Recommendation Report for Planning Permission for Works or Extension to a Dwelling

REF NO: BE/26/26/HH

LOCATION: 35 North Bersted Street
Bersted
PO22 9AA

PROPOSAL: Ramped access across grass verge to create new driveway to front of property.

35 North Bersted Site Plan

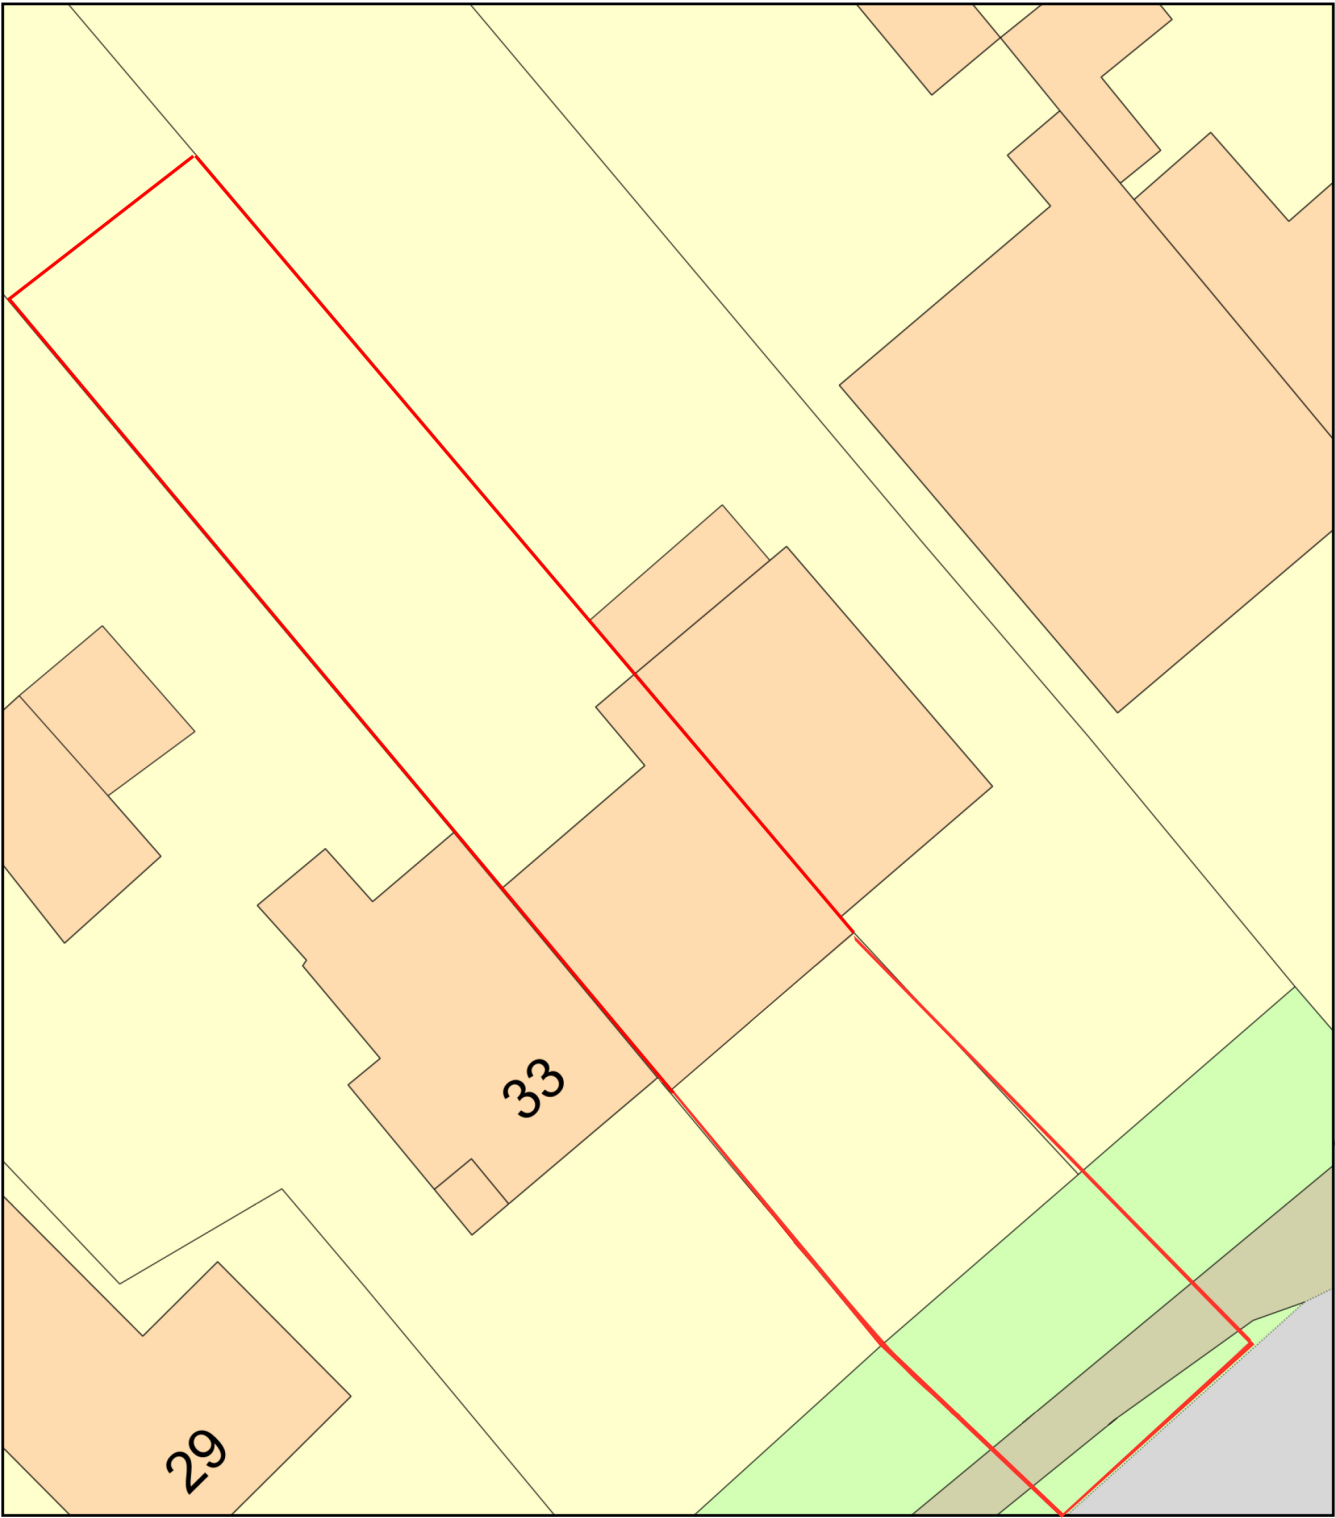
The proposal seeks ramped access across the grass verge to create a new driveway to the front of 35 North Bersted Street to provide a new vehicular access to the front of the property. The proposed works would cross over an existing layby, grass verge, and public footpath connecting to a proposed permeable parking area that would have a width of 6.7m and depth of 8m. The proposal would result in the creation of two on-site parking spaces.

The property is located in a residential area with an existing pathway that dissects the grass verge leading up to the front of the dwelling. The plans demonstrate a sufficient visibility splay of 3.8m at the proposed point of access. There are existing dropped kerbs that cross the same layby at neighbouring properties (No.29, No.31, No.37, and No.39 North Bersted Street), and a similar access arrangements across a layby at No.53 North Bersted Street. These dropped kerbed arrangements provide vehicular access to parking created to the front and side of the properties and all cross a layby.

The proposed development is in accordance with relevant development plan policies and as such is recommended for approval subject to the following conditions and informatives. It is acknowledged that the submitted plans indicate new boundary treatment and a retaining wall, however these do not form part of the current application and no details of these elements have been submitted.

- 4 INFORMATIVE: The applicant is advised that the vertically slatted screen with planting and retaining wall does not form part of this application as no details of these elements have been submitted.
